117 Preble Street

Schlotterbeck Block (55 Unit Apt.)

**RE: B7 Design Review Comments
Level III Site Plan & Subdivision Application
Schlotterbeck Block – 117 Preble Street**

To: Elizabeth Boepple, Chair and Members of the Portland Planning Board
 From: Shukria Wiar, Planner
 Date: November 20, 2015
 Re: Schlotterbeck and Foss Building, 117 Preble Street, Schlotterbeck Block, LLC
 Project #: 2015-174 CBL: 033 E001 001 and 033 E005 001
 Meeting Date: November 24, 2015

Drawing file: 1. Original Plans / L2.0 Layout.10-5-2015.pdf

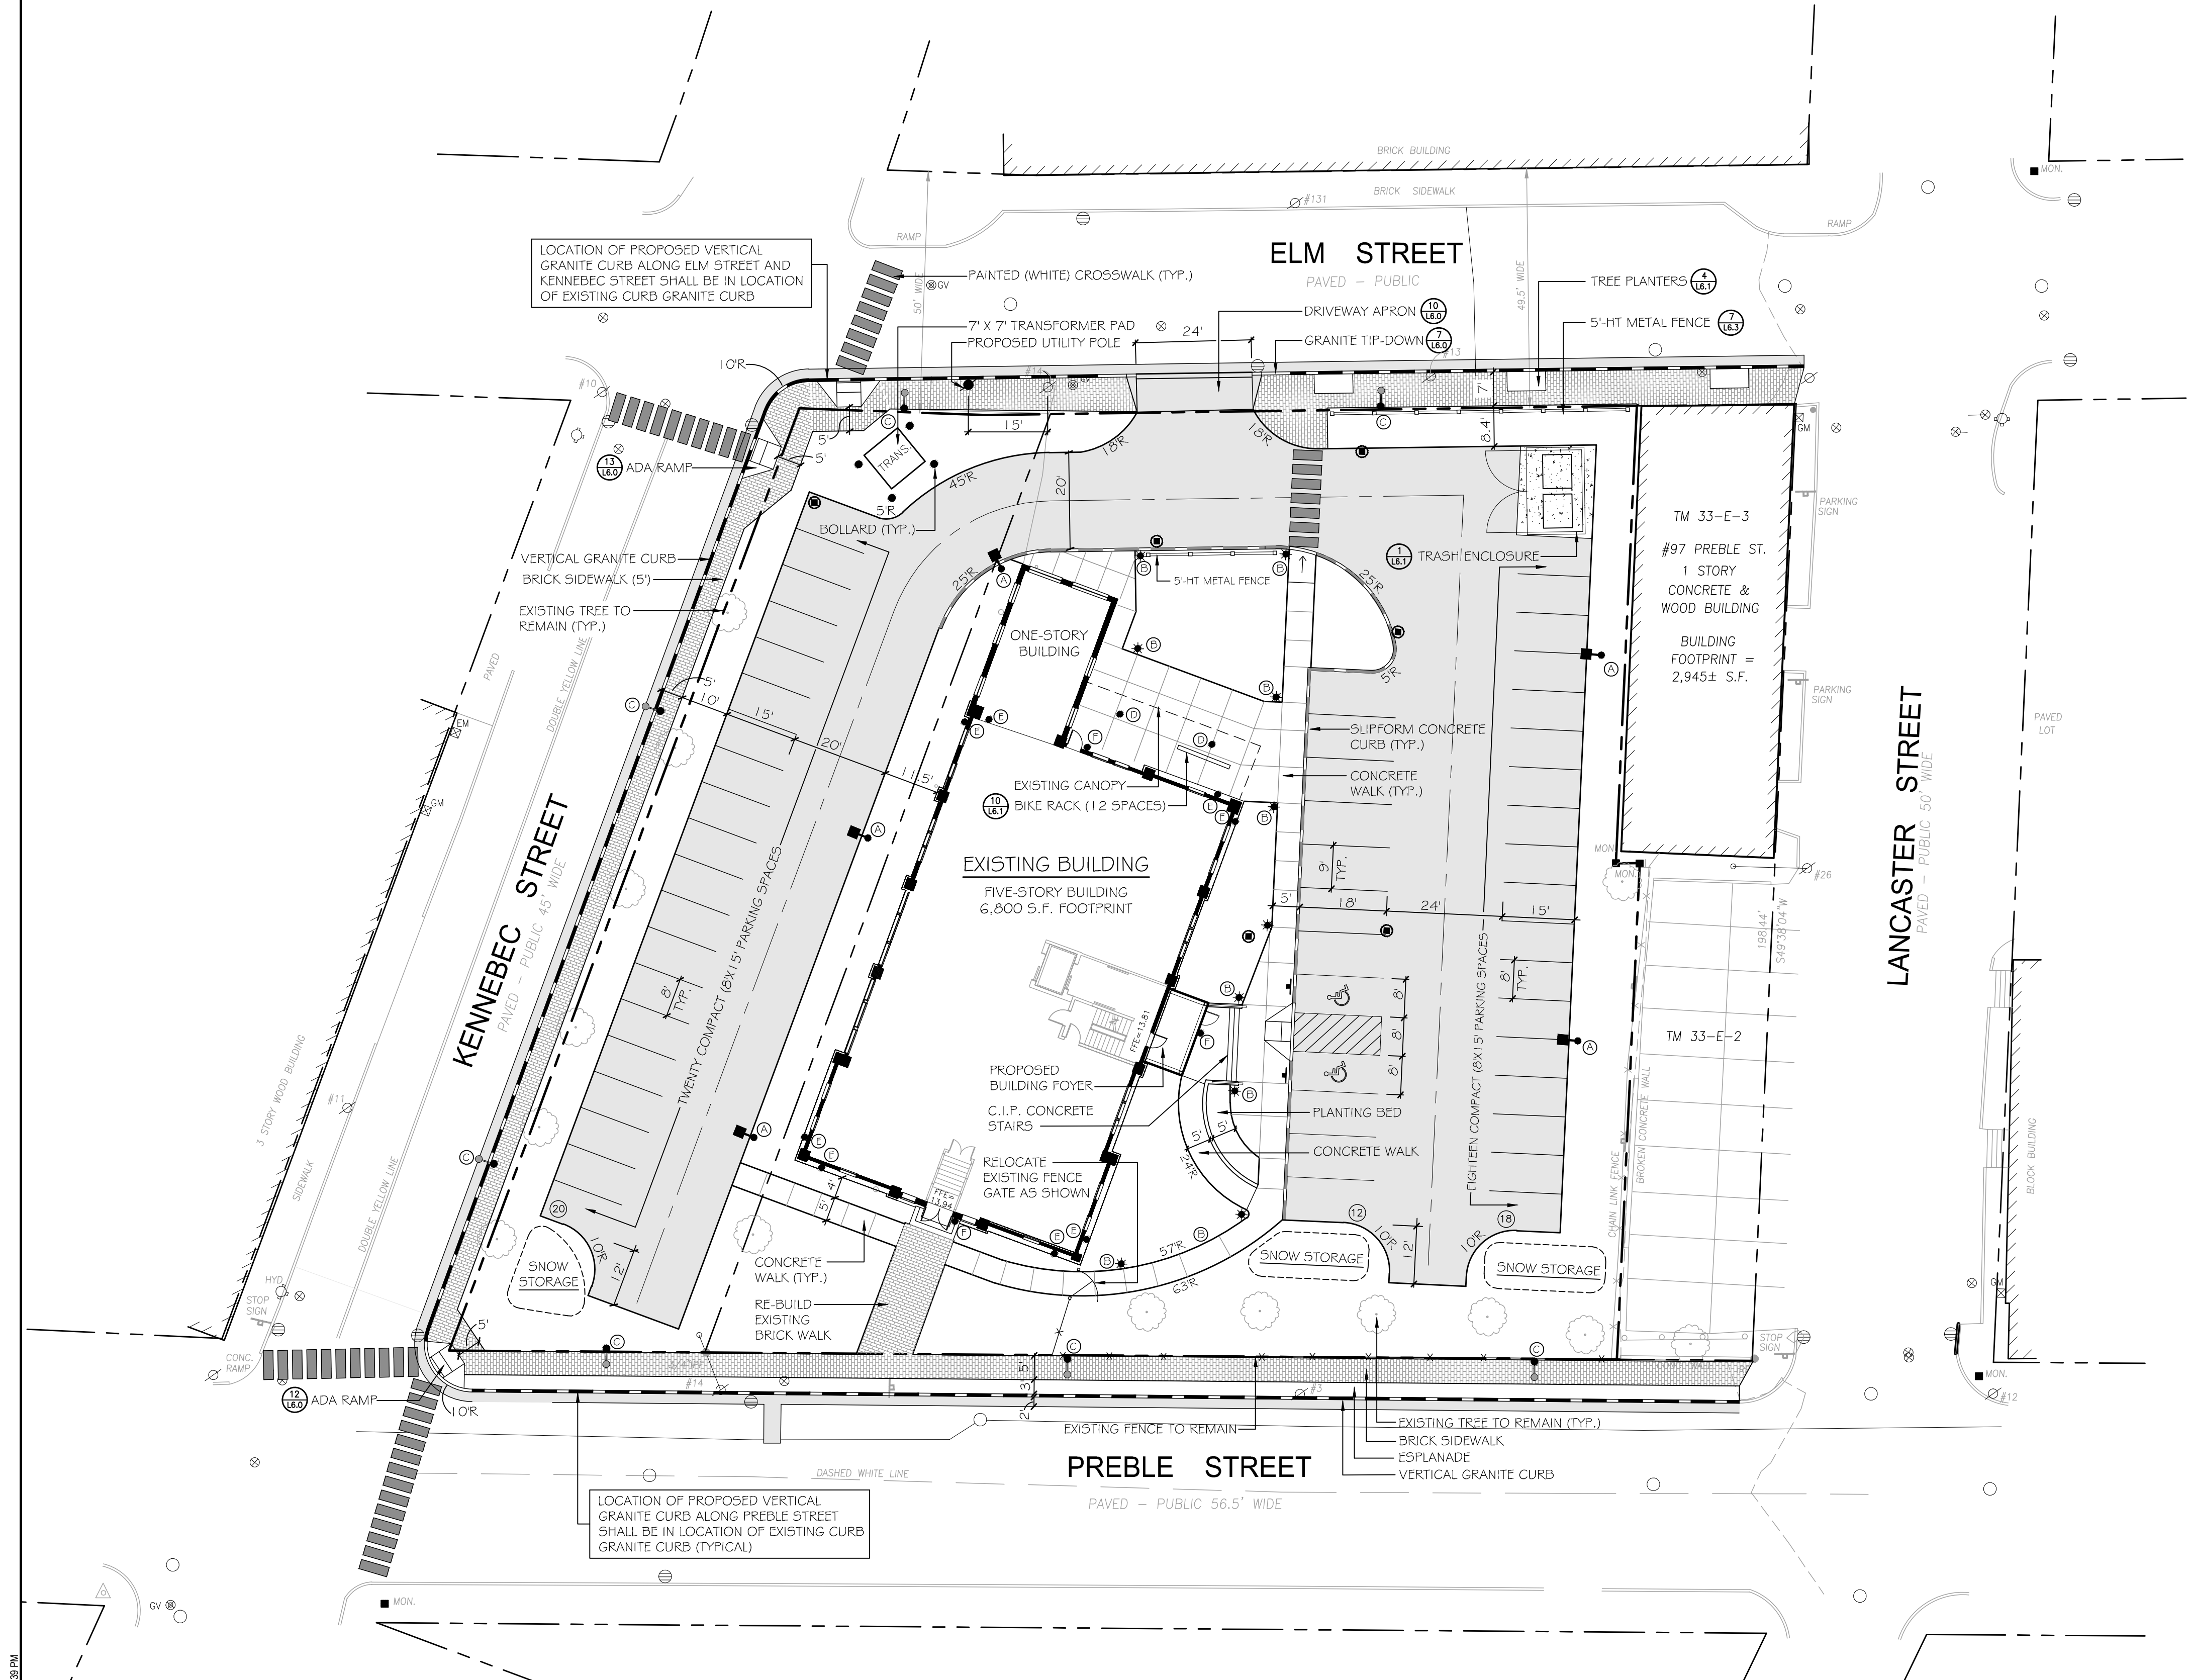
1. **B-4: Sidewalks less than 5' width:** The plans will be revised and all sidewalks will be at least the minimal width of 5-feet. We have been meeting with city staff (Bruce Hyman and Jeff Tarling) in an effort to resolve this issue.
2. **B-9: Preble Street Esplanade:** Revised plans will eliminate the esplanade along Preble Street. The sidewalk will be 8' wide with the elimination of the esplanade.
3. **B-11: Lighting:** As discussed in Exhibit 15 of our October 6, 2015 application, the applicant intends to use the Medium (19'-3") Bayside street light fixture along Elm, Kennebec and Preble Streets.

The sidewalks are currently undersized and should be widened where possible. The esplanade should be removed.

The project significantly exceeds the allowable percentage of compact parking spaces for the site. I would suggest the row of parking along Kennebec Street be converted to standard 9'X18' parking spaces and some of the area abutting the building be used for the added depth (3 feet). Under this scenario, I'm supportive of a waiver for aisle width.

Sheet No.: **L5.0**

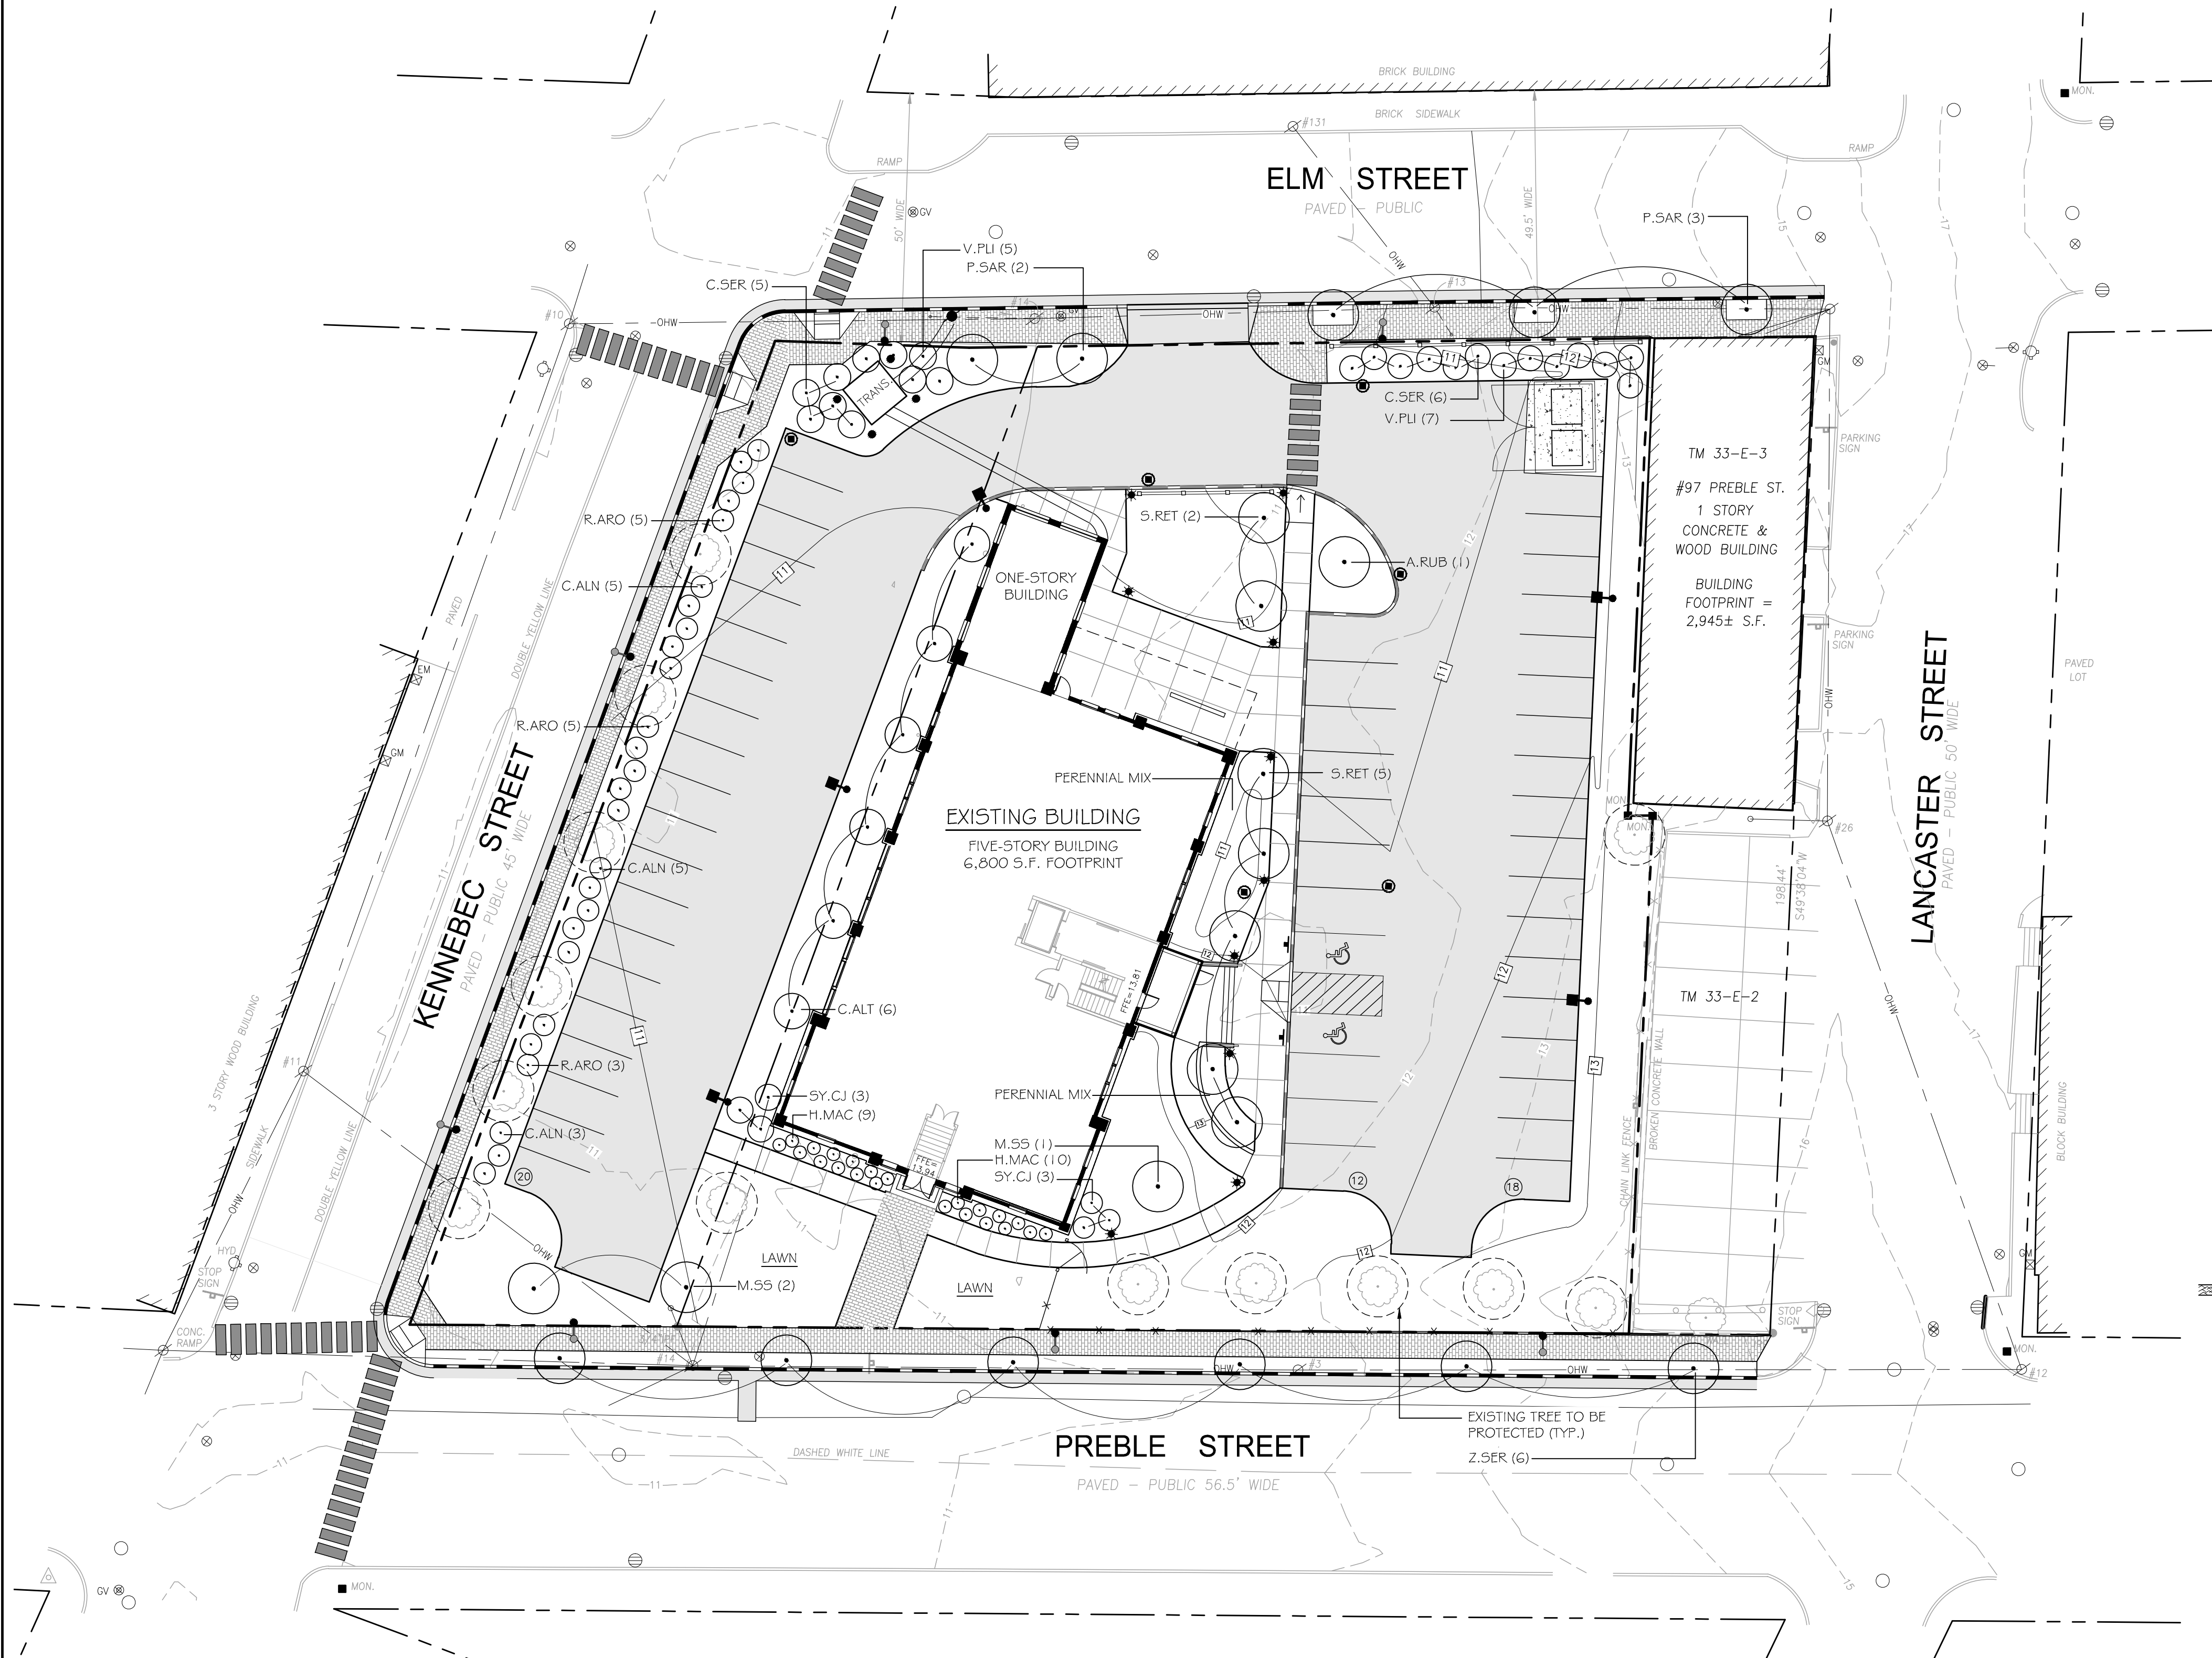
1. **C-6 Surface Lots -- Landscape Screening:** The parking lots screening plants (Hummingbird clethra, red-twig dogwood, gro-lo sumac) were chosen for two reasons. First, these plants will withstand snow-loads that will occur along the perimeter of the parking lot. Secondly, we chose deciduous shrubs because we have safety concerns about installing evergreen shrubs at this site.

2. **C-6 Surface Lots – Screening from Preble Street:** The existing mature crabapples trees along Preble Street will be preserved and will provide substantial screening for the east parking lot. These existing trees will dominate the streetscape because of their scale and mass.

- **Parking lot landscaping** - Additional parking lot landscaping is warranted along the Lancaster Street side of the lot to meet parking lot landscape standards. The additional landscape material can be planted in groups or clusters (for snow storage). This can be a mixture of upright trees and shrubs.
- **Dumpster enclosure** - The dumpster enclosure should meet standards in regard to treatment of the enclosure. An extra section of fence between the dumpster and the fence along Elm Street may be of interest to reduce the points of access into the site for security reasons.

- Landscape screening should be of sufficient type and height to effectively screen surface parking year round.
- The relationship of the surface parking to the building and Preble Street causes the surface parking to dominate the streetscape. Surface parking should ideally not occupy the front yard and should be adequately screened from the street.
- Landscaped islands are not proposed as outlined in standard. It is unclear if the surrounding landscaped areas are intended to substitute for the islands.
